From: [Housing Manager DAU](#)
To: [LAPS](#)
Cc: [SIDS](#)
Subject: ACP-324305-26 Proposed development of a 680MW Gas-Fired Generation Station
Date: Tuesday 21 July 2026 15:43:15
Attachments: [20260721 SID-DF-2026-027.pdf](#)

Our Ref: SID-DF-2026-027

Proposed Strategic Infrastructure Development (SID): Proposed development of a 680MW Gas-Fired Generation Station
--

Client: Kilshane Energy Ltd.	Dwg No. 01
Drawing Title: Landscape Masterplan	Scale 1,500
Job No. 1961	Date 12/06/2025

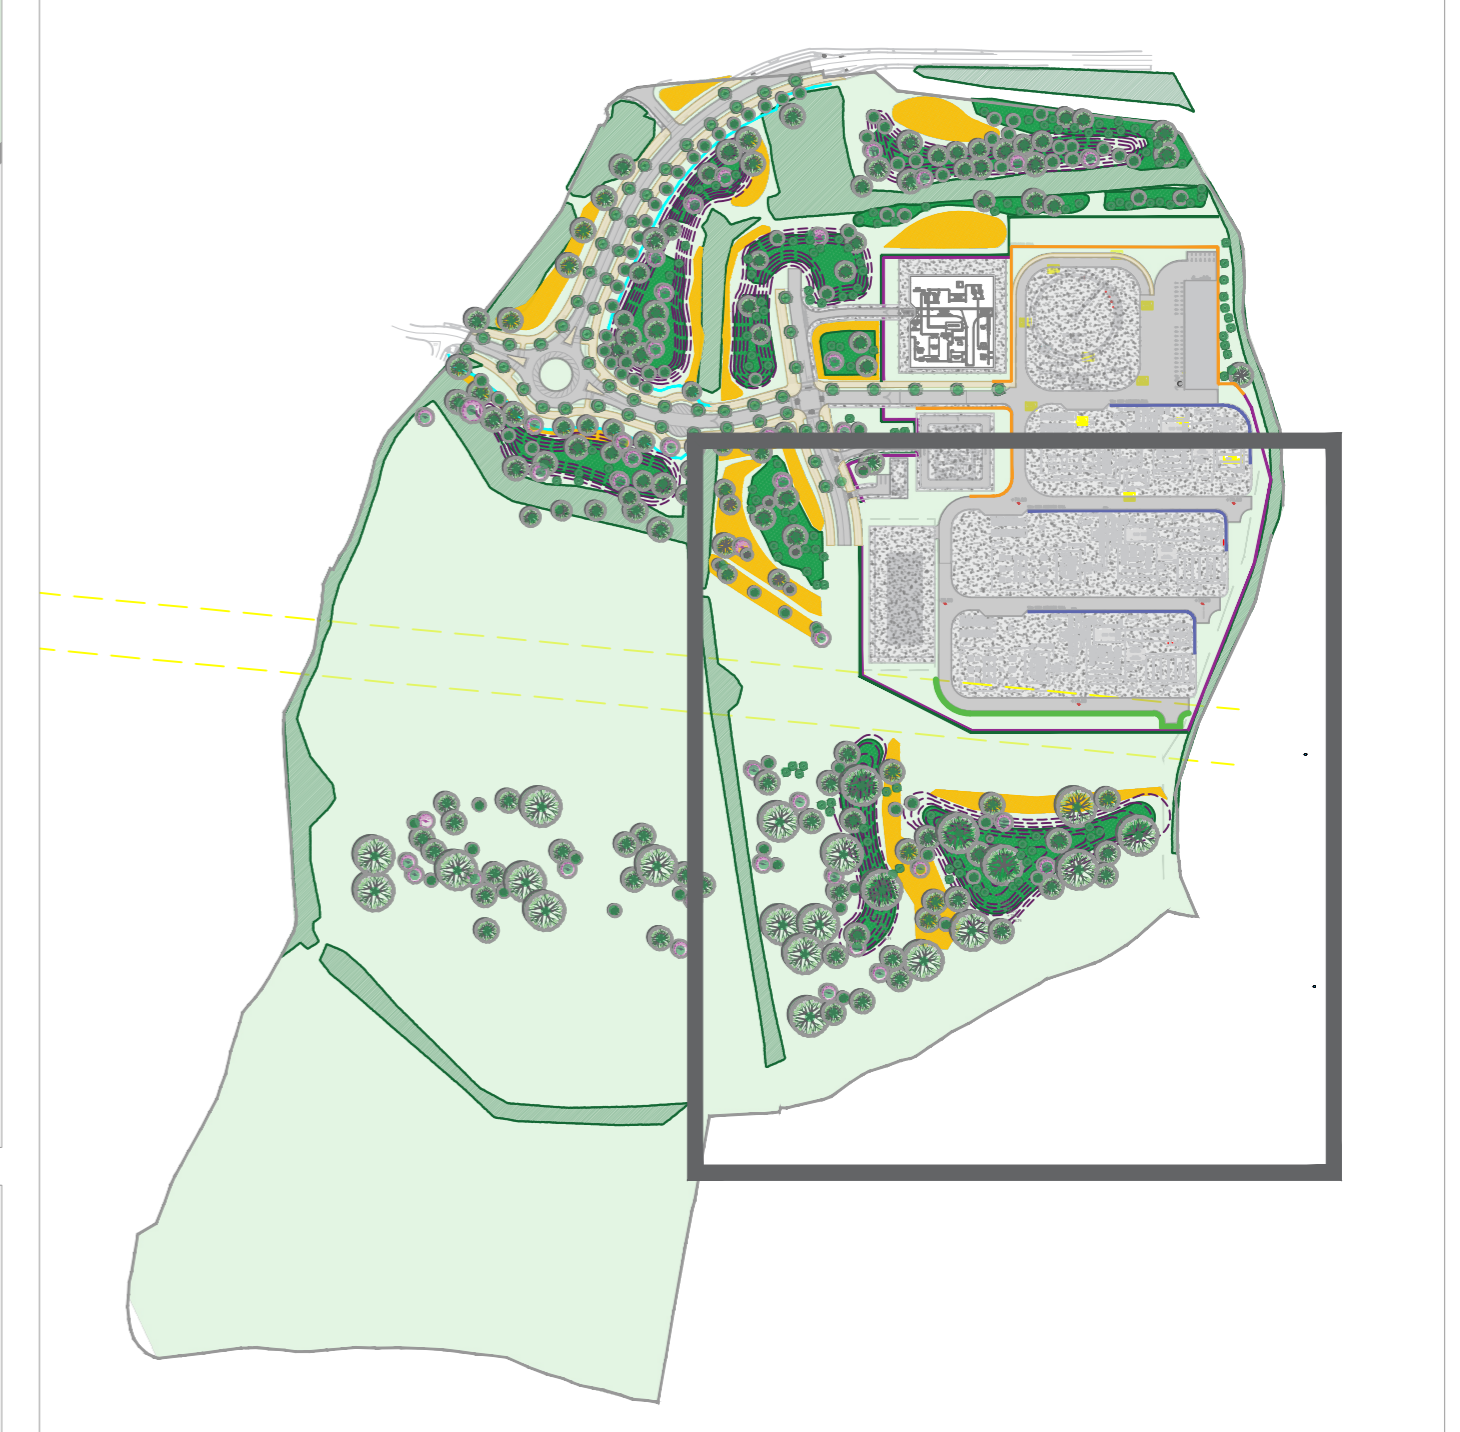
However, it is noted that as part of the landscaping of the proposed development it is intended to sow commercially sourced wildflower seed mixtures to establish wildflower meadow areas. Such an approach to the landscaping of the proposed development would not conform to good practice, as the planting of commercially available 'wildflower' seeds, even of Irish origin, in an area such as Kilshane, where wildflower species are already present, could threaten local biodiversity through the cross-pollination of adult plants grown up from the sown seeds with populations of flowers of the same species already occurring in the vicinity.

In this context it should be noted that the All-Ireland Pollinator Plan advises against planting wildflower seed outside a garden setting. To clarify, the following points are taken from the Position Paper by the Dublin Naturalists' Field Club entitled 'The case against 'Wildflower' seed mixtures' which is endorsed by the All-Ireland Pollinator Plan and reproduced on their website.

The genetic integrity of what remains of rare and ecologically significant native species is therefore threatened by the introduction of seed from external sources. Pollen from these geographical insertions and intrusions cannot be prevented from fertilising the local native stock of the same species or causing hybridisation with other closely related species.

Any wildflower meadows to be incorporated into the landscaping of the proposed development should therefore be established either by allowing the areas where the meadows are to be established to be colonised naturally by wildflowers originating from the soil seedbank and/or by dispersal, or by sowing locally harvested wild plant seeds. Whichever method is used to establish wildflower meadows within the proposed development these meadows may only be maintained in the long term if subjected to an appropriate mowing regime.

That, prior to the commencement of development on site, the applicant should submit to the planning authority for its written agreement an amended landscaping plan, omitting from this plan the sowing of commercially sourced 'wildflower' seeds as proposed in the original landscape masterplan for the proposed development, and instead substituting a methodology for the establishment of wildflower meadows on the development site by germination of wildflowers from the existing site soil seed bank or natural dispersal and the maintenance of these meadows by implementing an appropriate future mowing regime.
